Your Ref: OWPC6523
Our Ref: FP/133/15/HH 22-06-2015
Please ask for:
Mr D Vick

Loft conversion & rear extension. Amendments to approved application FP/198/14HH
4 The Midway Felpham

Proposed Elevations

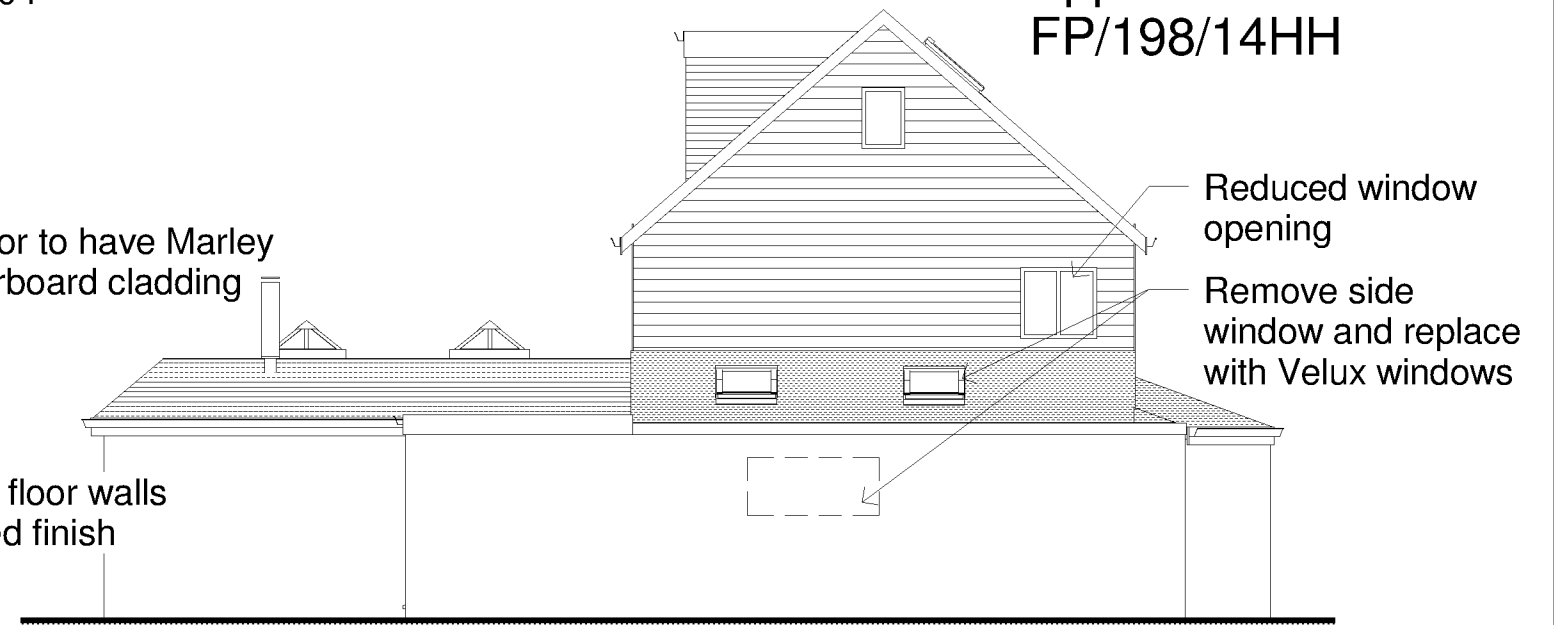
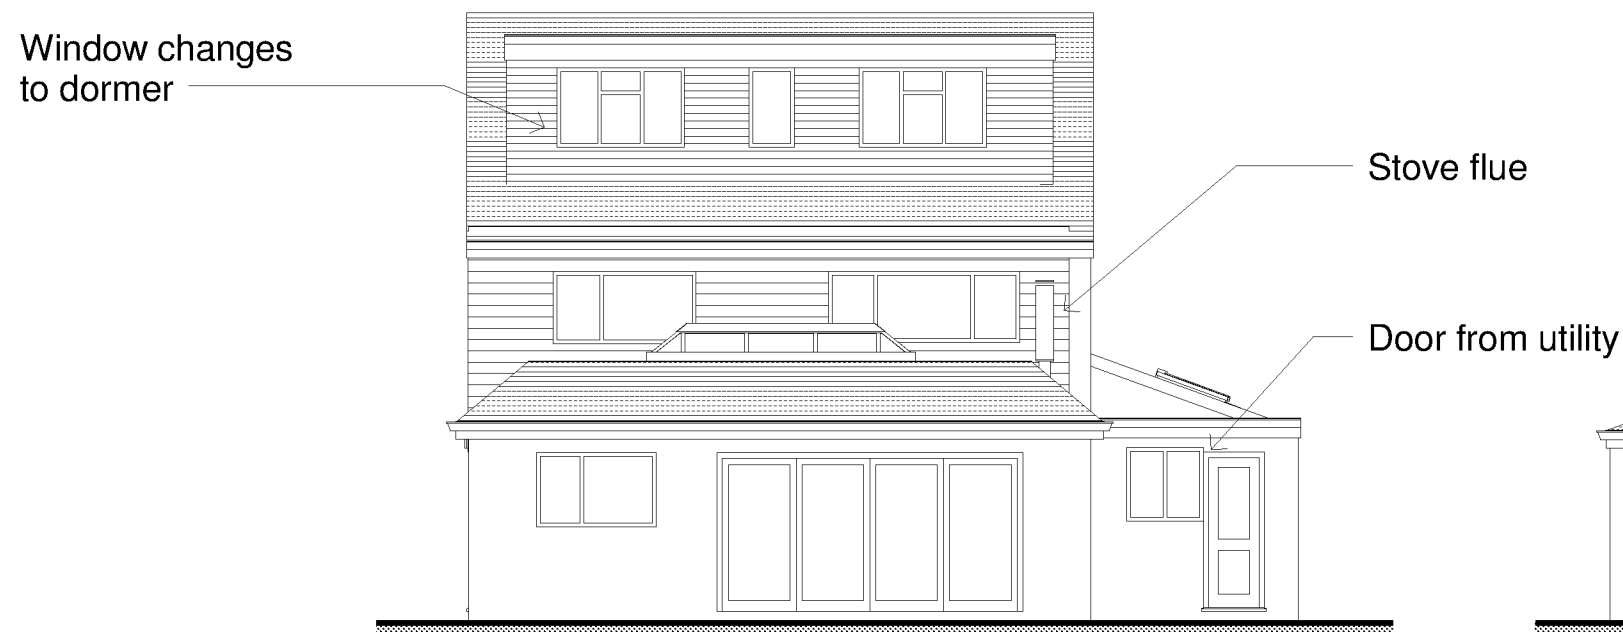
We are concerned about the loss of privacy to the rear of adjacent properties and gardens and assume that the windows to the rear of the 2nd floor dormer extension will use obscured glass in common with those of No 6 The Midway
